DESIGNERS RESPONSE

Shop Lane, Kirkheaton, Kirklees

Road Safety Audit Stage 1

2023-11 Kirkheaton RSA1 – Revision 0

**SHOP LANE**

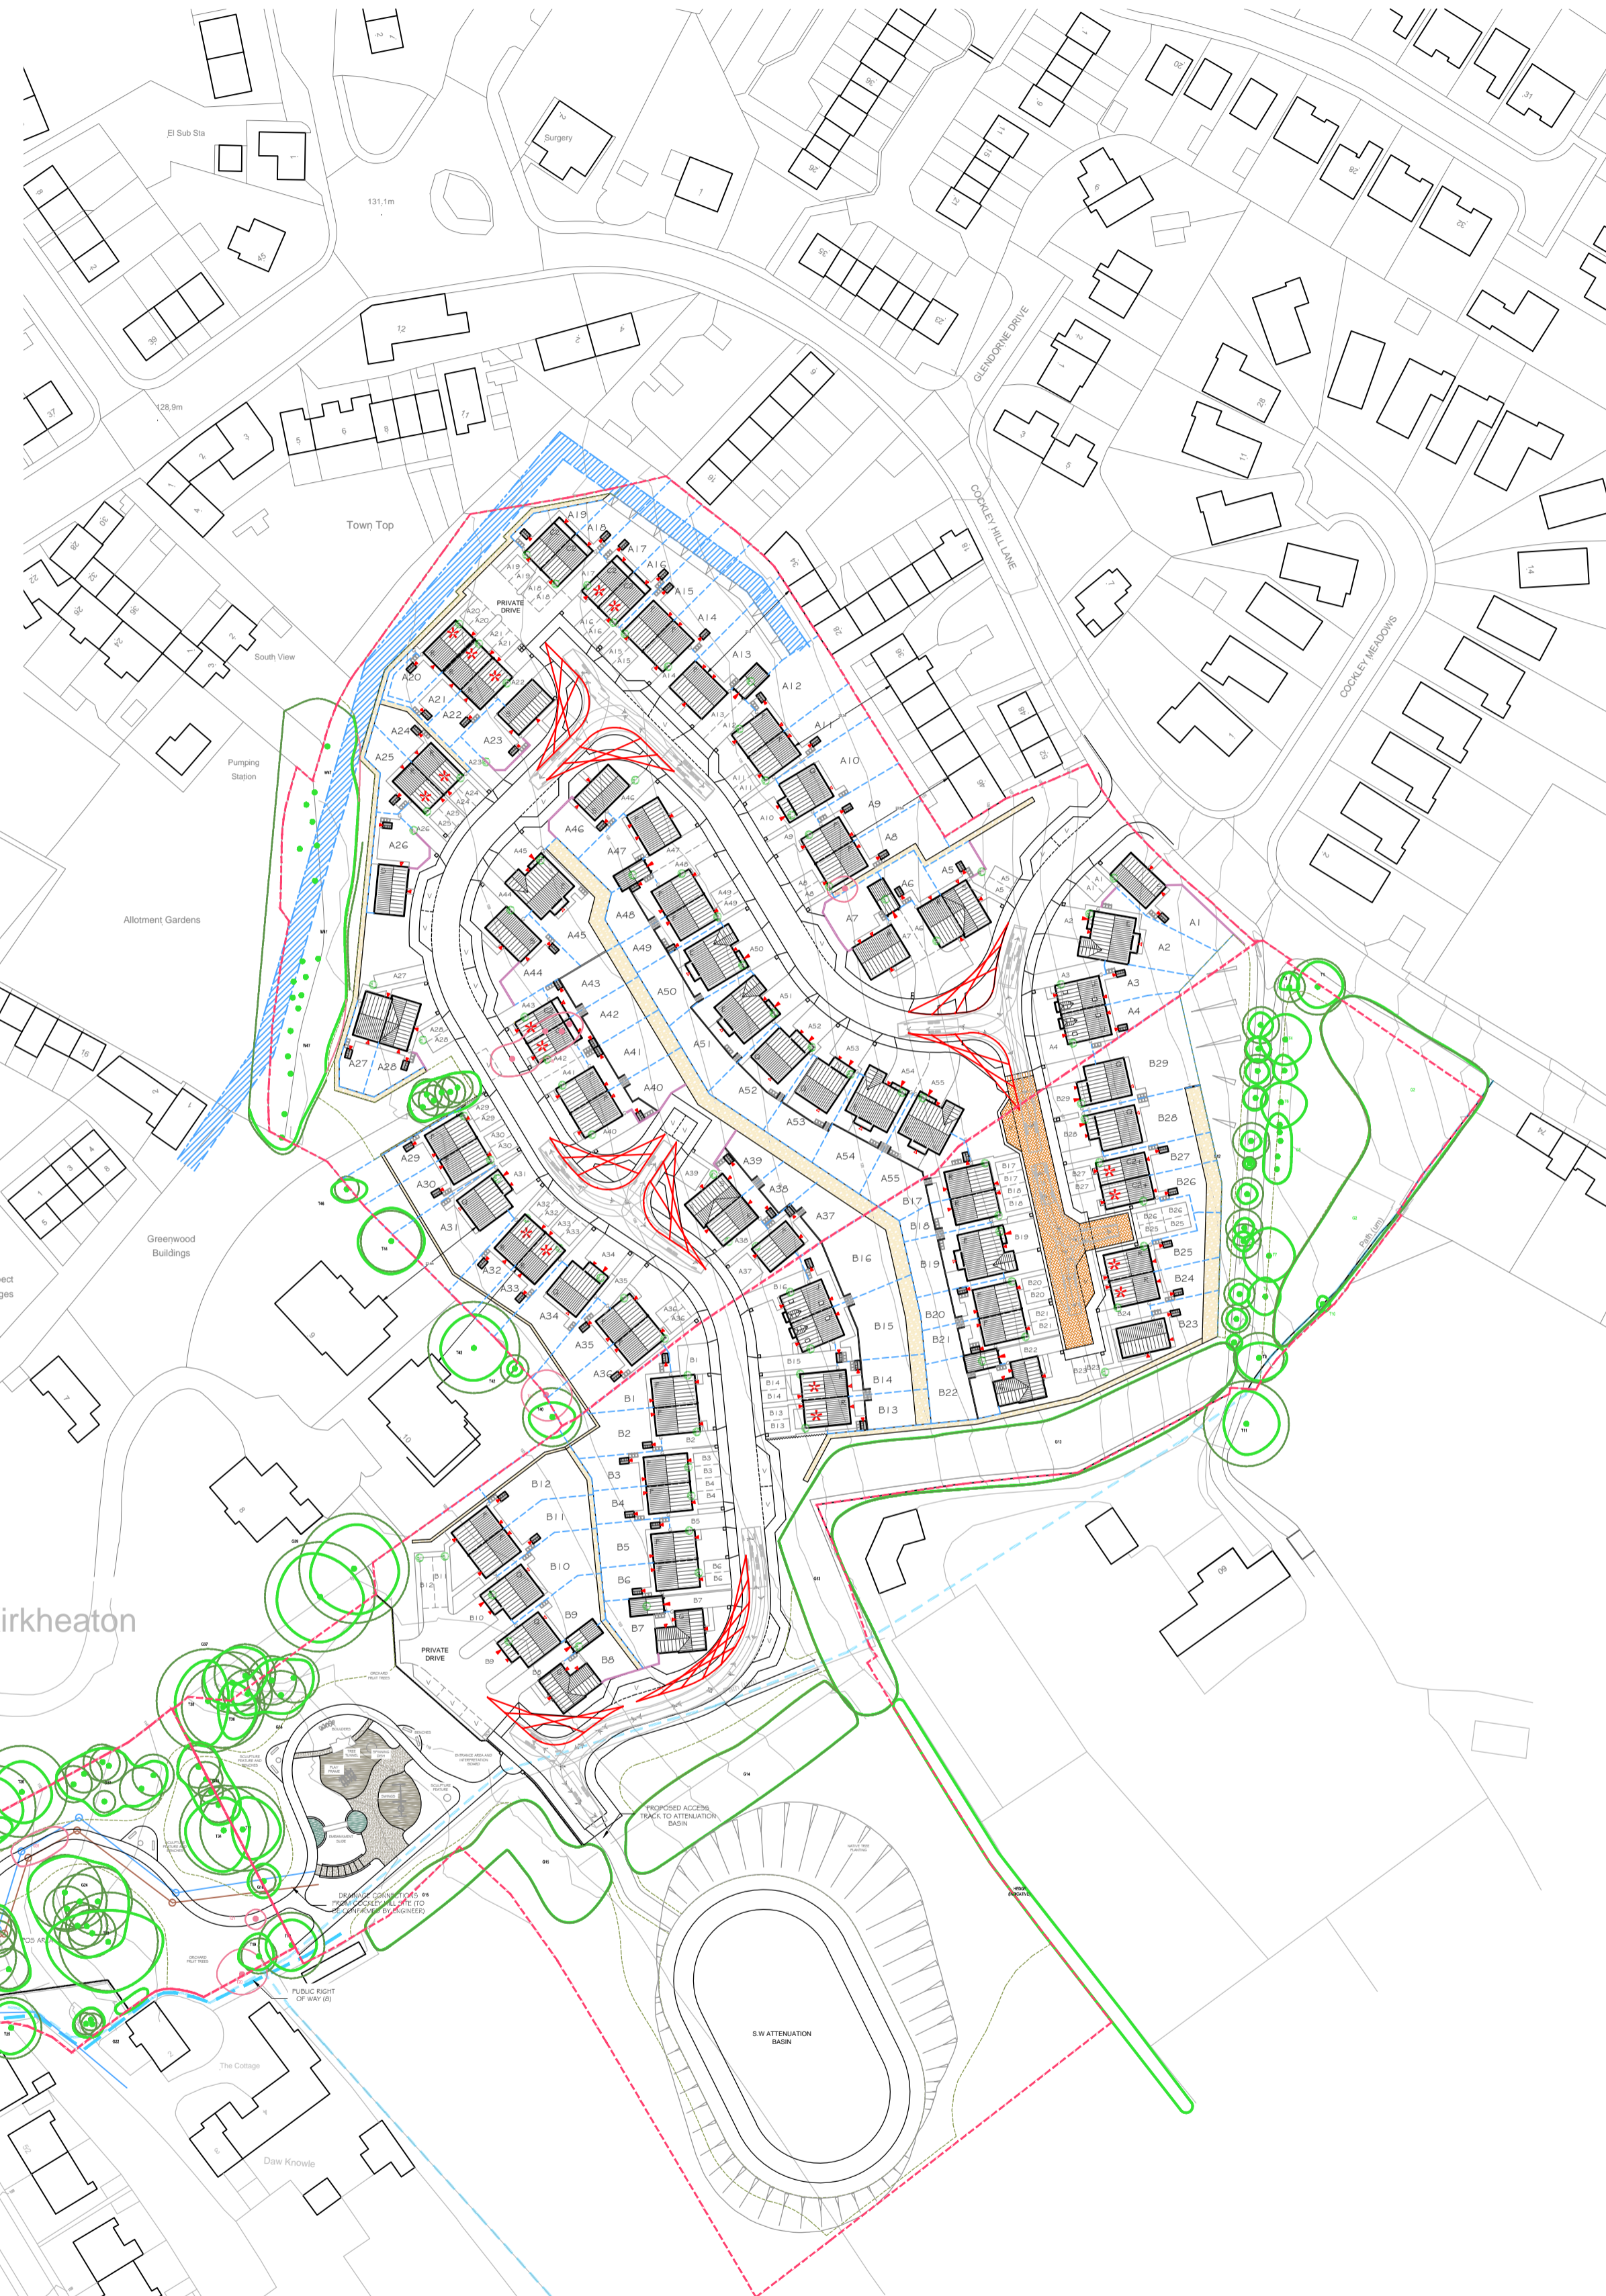
Summary: Specific Road Users – Lack of dropped crossing on a desire line may increase the risk of collisions involving users with mobility issues.

There is a desire line for pedestrians between footways which have no provision for pedestrians with mobility issues, specifically those users with prams, wheelchairs or mobility scooters. The alternatives for these users may require them to use drop kerbs provided for driveways or to cross at locations where visibility to approaching vehicles may be otherwise compromised. This lack of dropped crossing on a desire line may increase the risk of collisions involving users with mobility issues.

It is recommended that a dropped pedestrian crossing with (ideally) tactile paving should be provided at these locations. Specific locations will need to consider the risk of vehicle overrun damage to the tactile paving by large vehicles, in particular refuse collection vehicles.

Accepted – dropped tactile crossings will be provided as part of the detailed design. Indicative locations are shown on the latest layout plan

Summary: Pedestrians – Unclear use may increase the risk of collisions involving pedestrians or other active modes.

This is a gated access for vehicles adjacent to Plot 9. This appears to have been an access to the premises that previously occupied the development site and appears to be retained in some form in the proposals. It is unclear as to the intended use but, given the previous use as access to the area behind numbers 1 to 6 Shop Lane, it could be reinstated for use by vehicles. There is a risk

here that a pedestrian or other active mode user may encounter a motor vehicle in this access resulting in a potential collision involving these user types.

It is recommended that use by vehicles is physically prevented. This could be by means of a non-passive bollard at each end or staggered gateway type arrangement.

Accepted – bollards are to be provided at both ends of the pedestrian link as shown on the latest layout plan. Further details will be provided at detailed design stage
